Report of the Head of Planning, Sport and Green Spaces

Address 363 CRANFORD LANE HARLINGTON

Development: Conversion of roof space to habitable use to include a rear dormer and conversion of roof from hip to gable end (Application for a Certificate of Lawful Development for a Proposed Development)

LBH Ref Nos: 66404/APP/2014/3530

Drawn No
02A

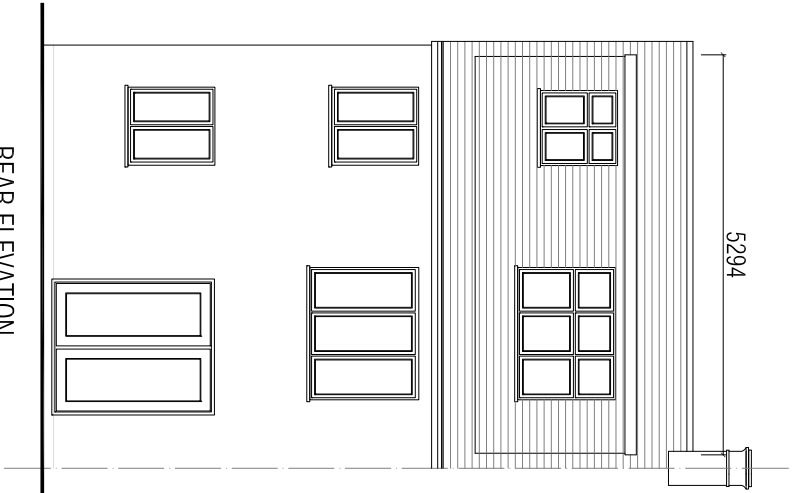
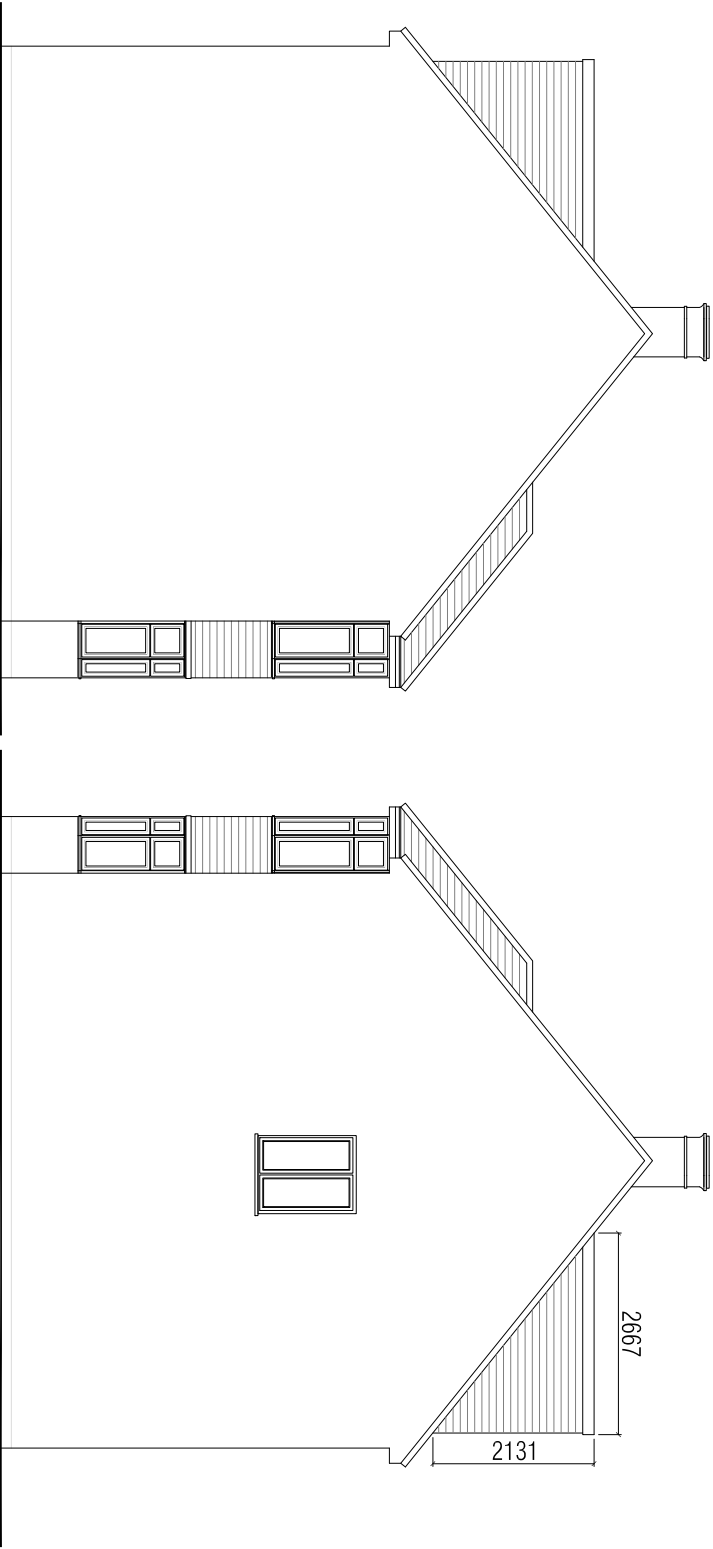
The plans indicate that the roof conversion would:

- i) Be no higher than the existing roof line.
- ii) Not extend beyond the plane of an existing roof slope which forms the principal elevation of the dwelling which fronts a highway.
- iii) Not exceed 50 cubic metres.
- iv) Not include a verandah, balcony or raised platform.

The volume of hip to gable :

$7.7/2 \times 3.1 \times 3.6$ divided by 3 = 14.32 cubic metres

The volume of proposed rear dormer :

$2.131 \times 5.3 \times 2.67$ divided by 2 = 15.01 cubic metres

This gives a proposed total loft extension of (14.32 + 15.01 cu m) of 29.33 cubic metres.
